KITTITAS COUNTY

MEMORANDUM

TO: All Staff
FROM: Public Works Planning Review Team
DATE: February 3, 2021
SUBJECT: SX-21-00001 Salak

Public Works has reviewed the Shoreline Exemption Application. Please see comments below:

SITE PLAN

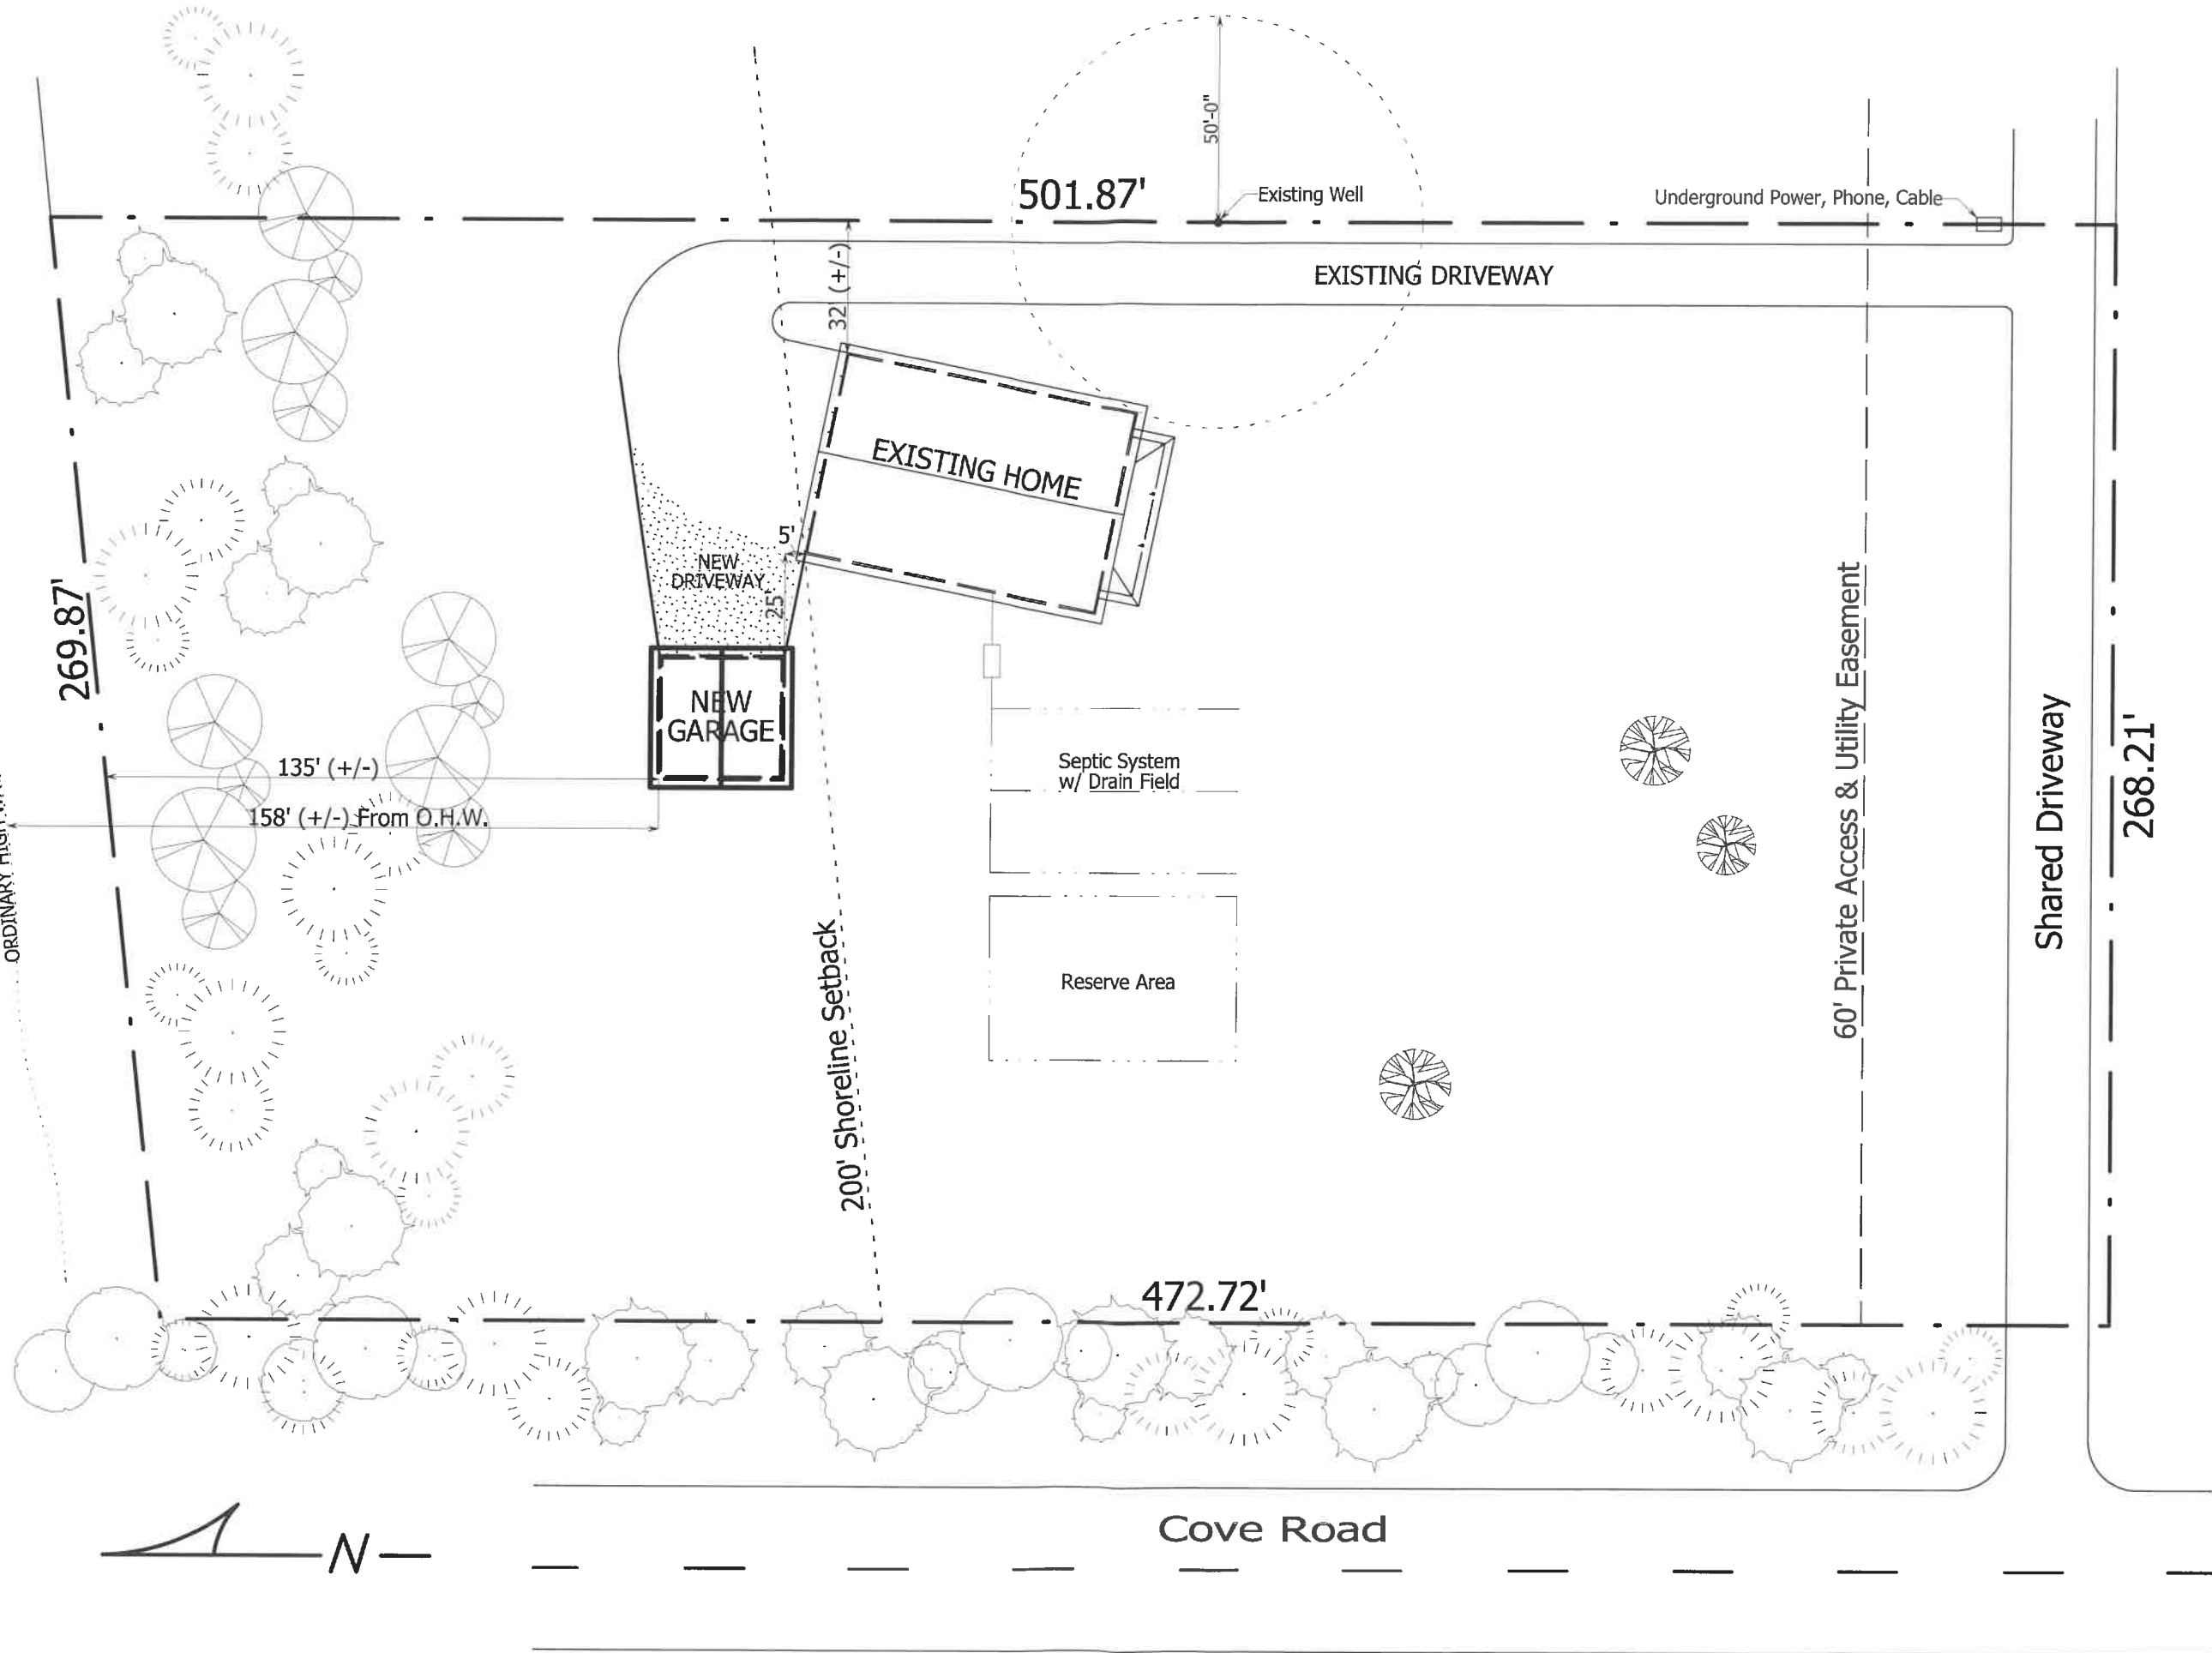
Public Works recommends denying the variance request. The proposed location is known to be at significant flood risk, as observed during the May 2009 flood event and historic flow channels located within 200 feet of the current Manastash Creek channel (and within 220 feet from Manastash Creek on the East edge of the property boundary). These flood risks can best be addressed by locating the structure outside the historic flow channels and south of the area that flooded in 2009, which will not occur if the variance request is approved.

Development of a detached garage on this lot will require a flood development permit and will need to comply with Kittitas County Code Chapter 14.08. Public Works staff is available for Technical Assistance.
